**ADC Planning Consultation
Response from the Conservation Officer**

Application Number	R/305/14/PL
Address	Land to the south of The Tiled Barn Station Road East Preston BN16 3AR
Description	Erection of 1 No. 3 bed dwelling & 1 No. 4 bed dwelling & demolition of existing garage & shed & erection of new car port
Case Officer	Mrs. A Gardner

PROJECT		Proposed development on site adjacent to Tiled Barn, Station Road, East Preston	
SUBJECT		Plot 1 - Proposed Plans and Elevations	
SCALE 1:100 @ A2	DATE Nov 2014	DRAWING No 2014 / 32 / 02	Rev A
DRAWN	CHECKED

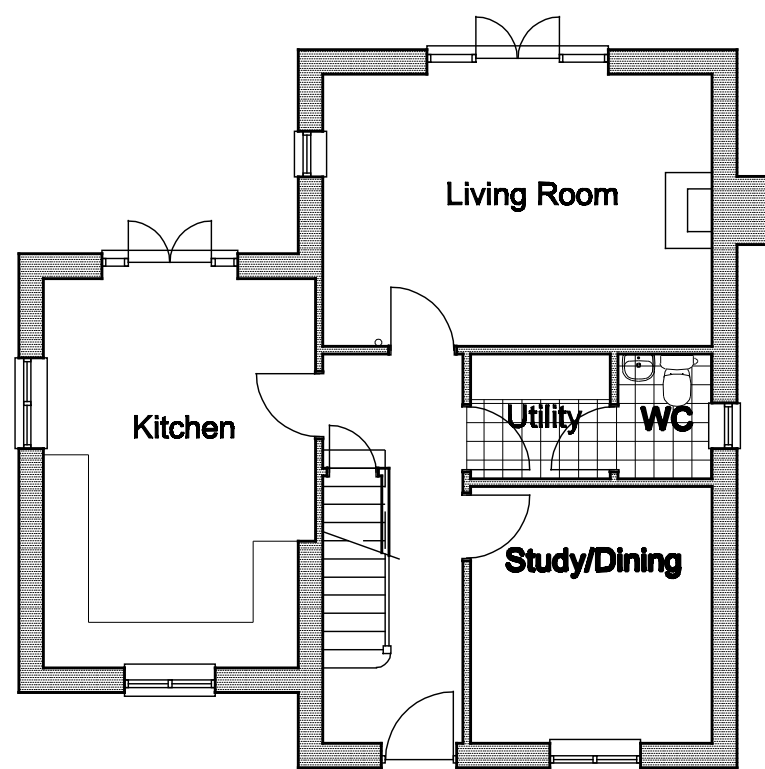
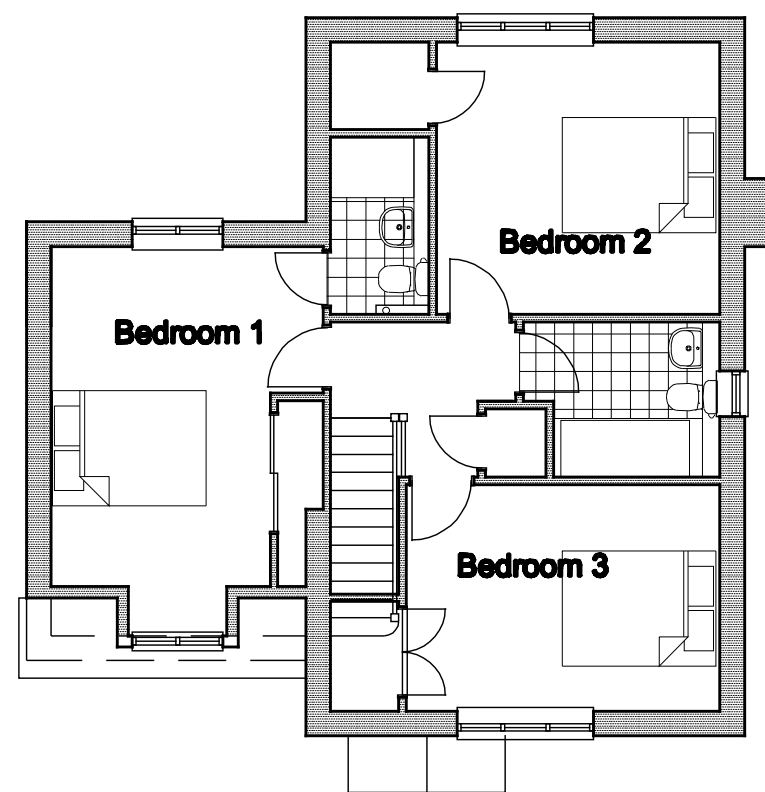
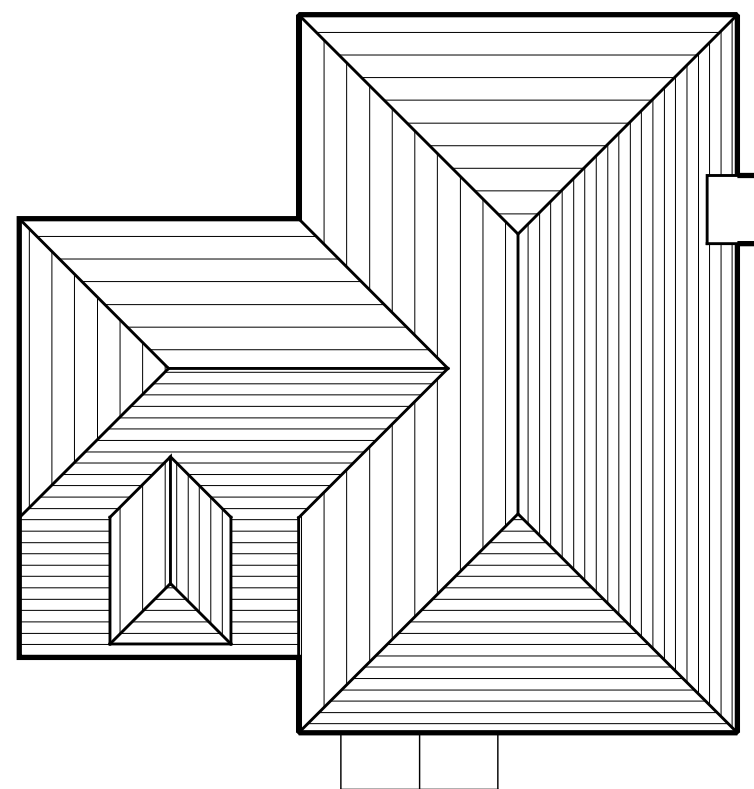
The proposal for two properties within the triangular plot appears to introduce a formality of building pattern that is witnessed outside the conservation area. It is considered that the intention to construct two properties in the site results in over development. A reduction to one unit would be more preferable.

Further, both properties appear to be very similar in appearance, with little variation in design.

Scale: 1:100@A1	Drawn: AR	Date: 21-11-14
Drawing Number: RCo 140 / 02	Revision:	00

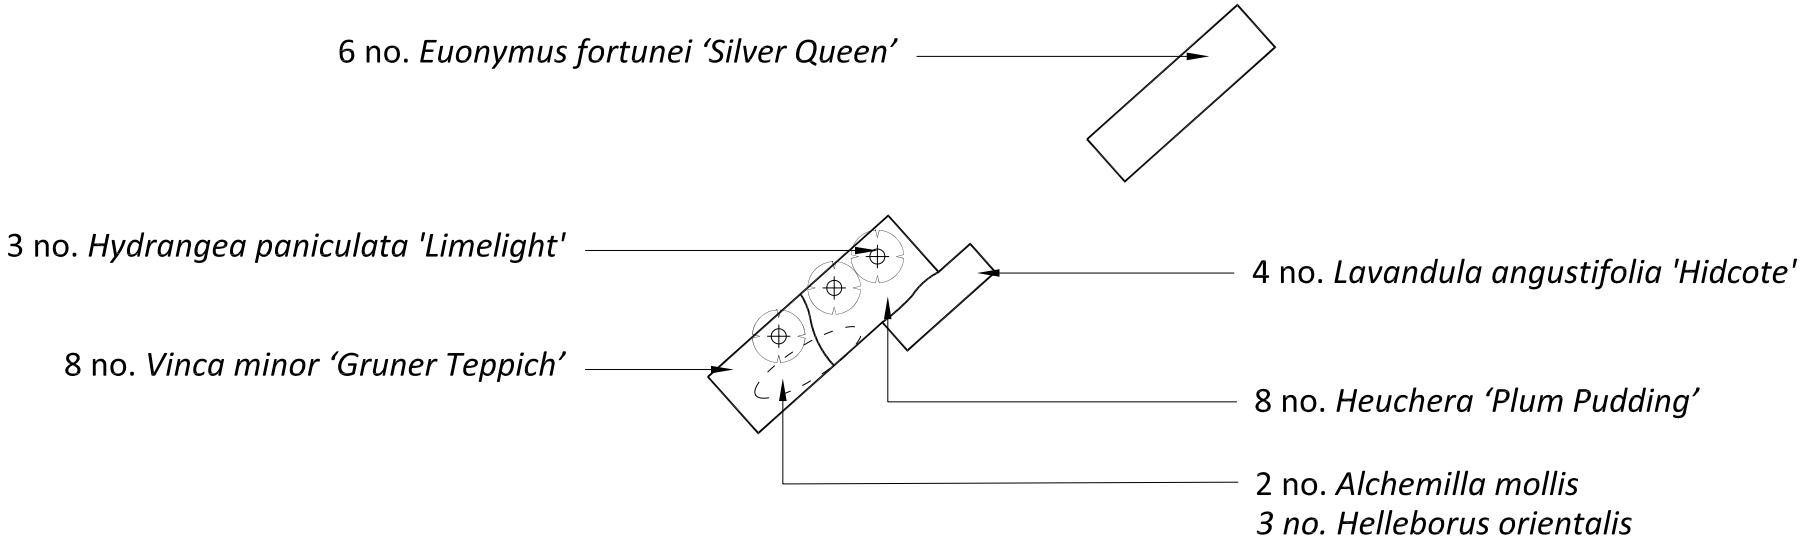
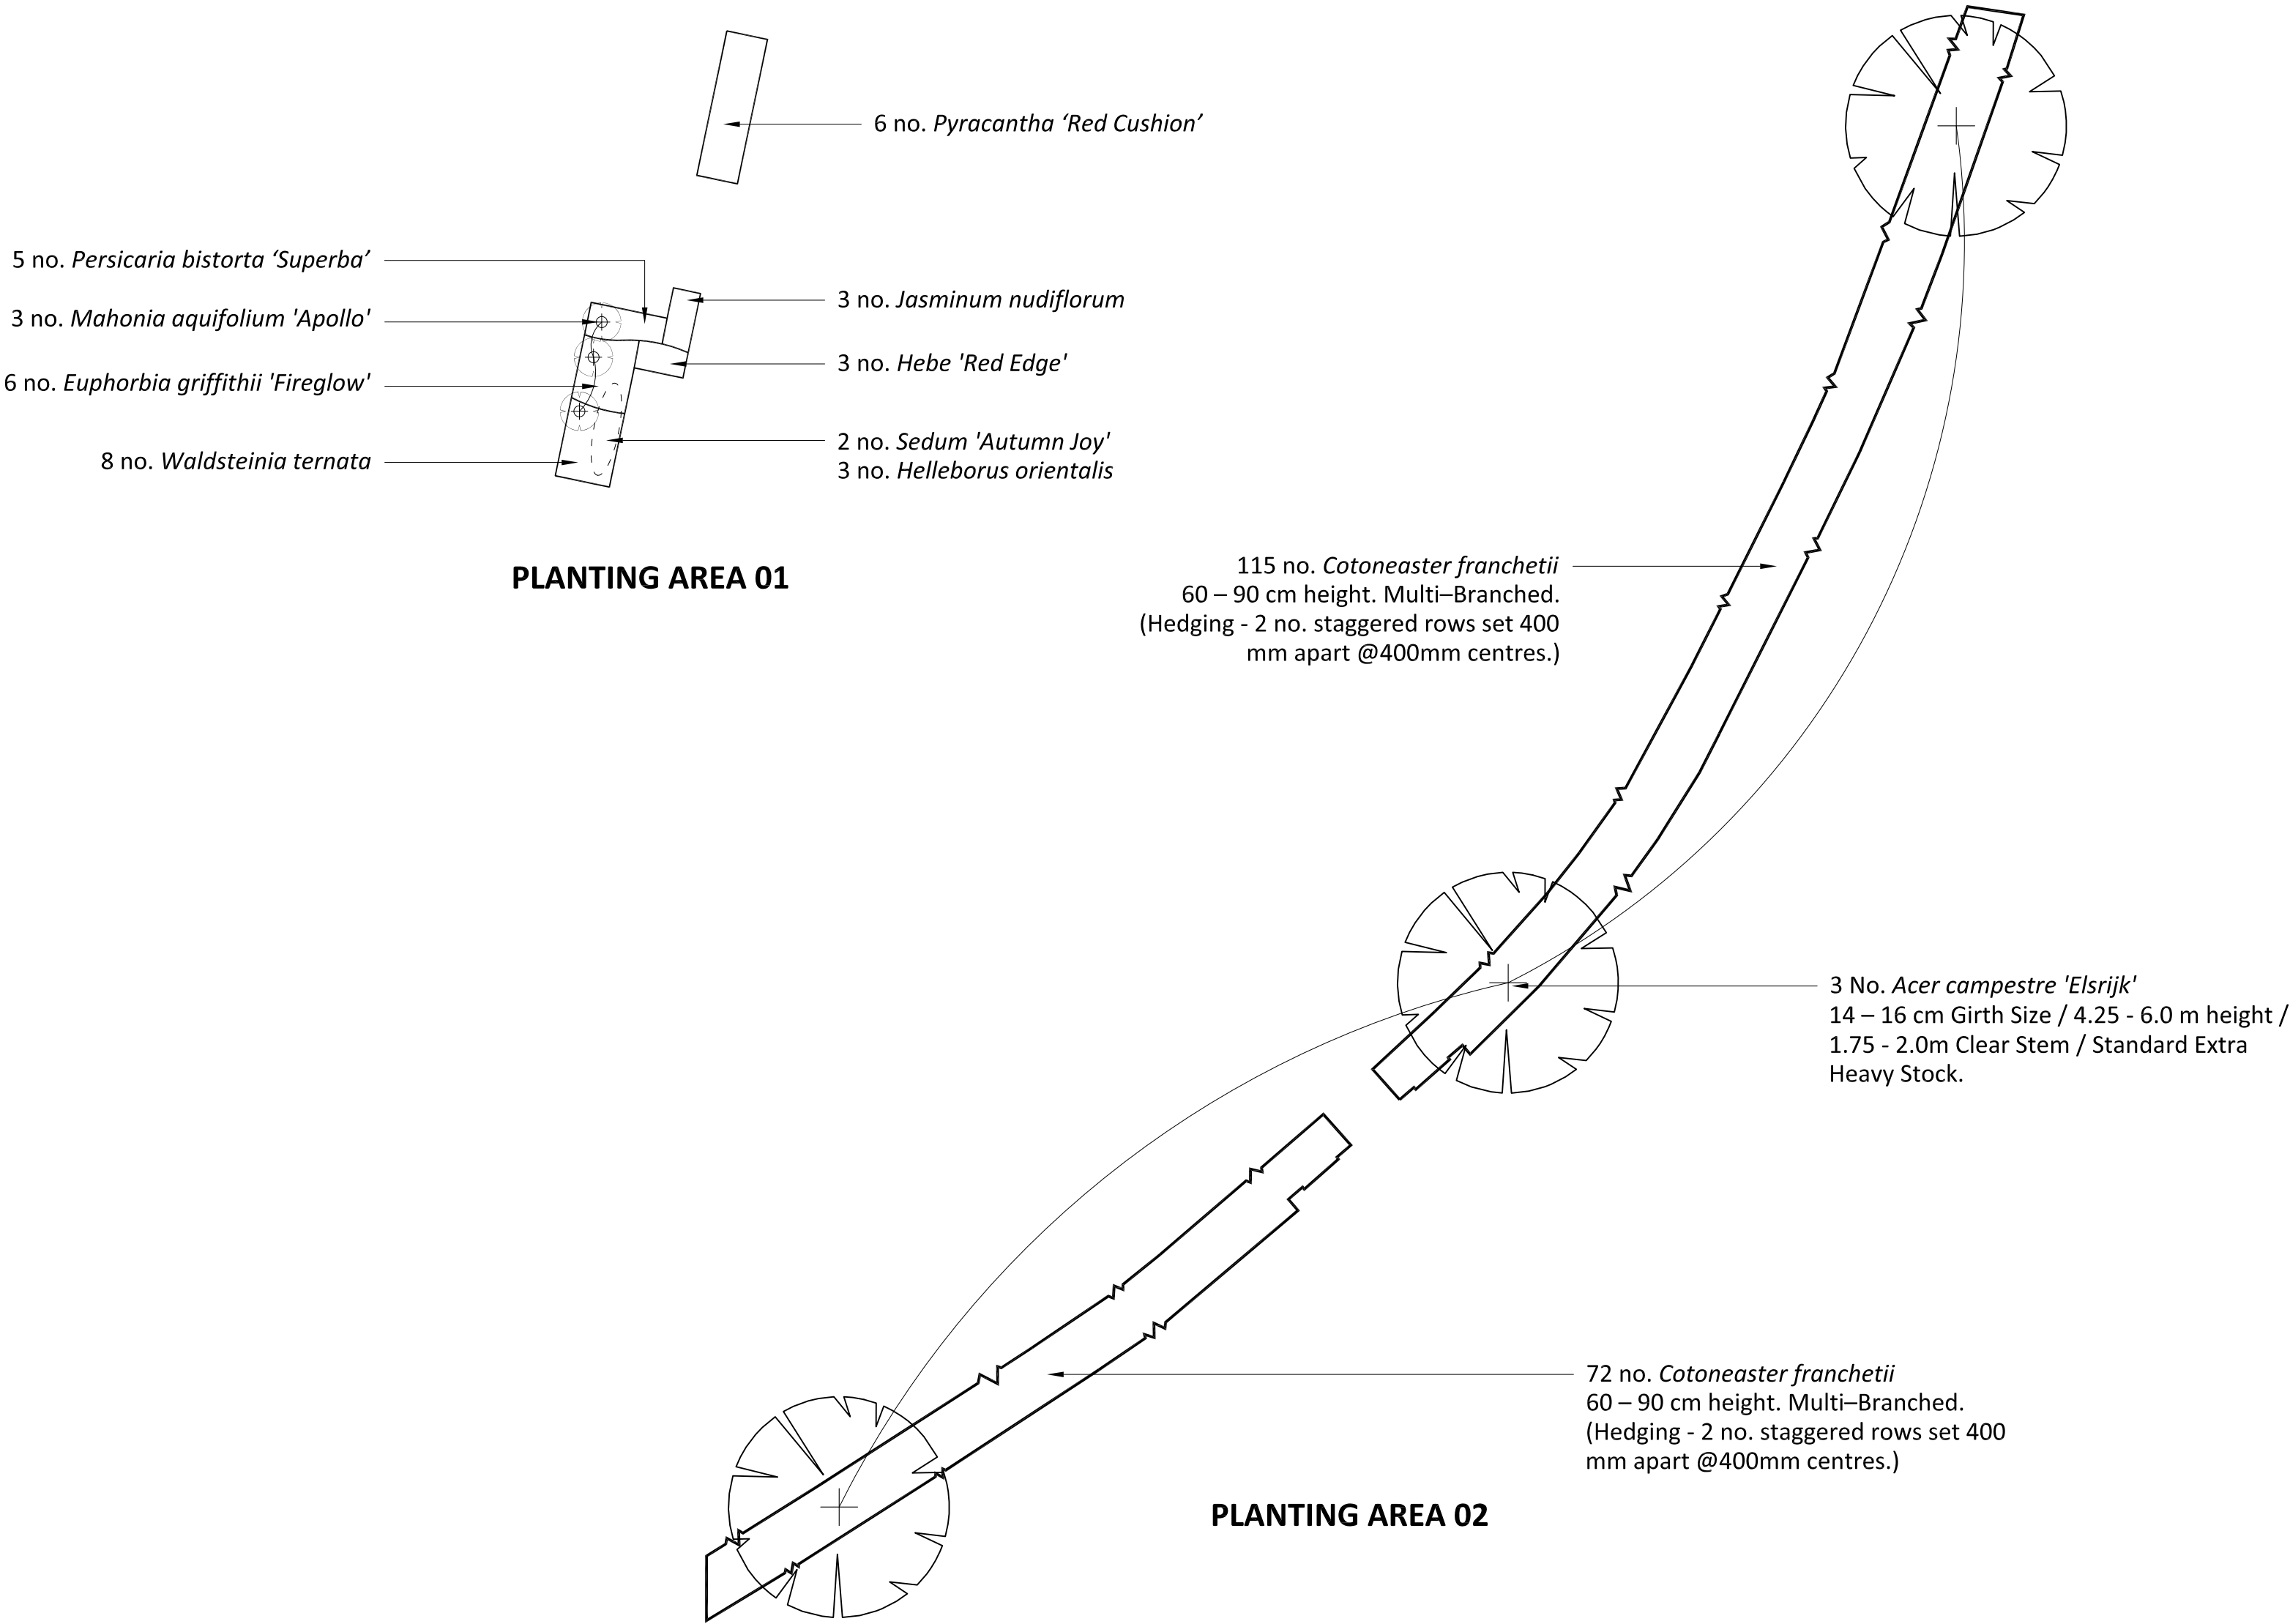
However, it is considered that the proposal to remove the existing boundary fencing and introduce replacement vegetation in the form of hedging and tree planting is supported.
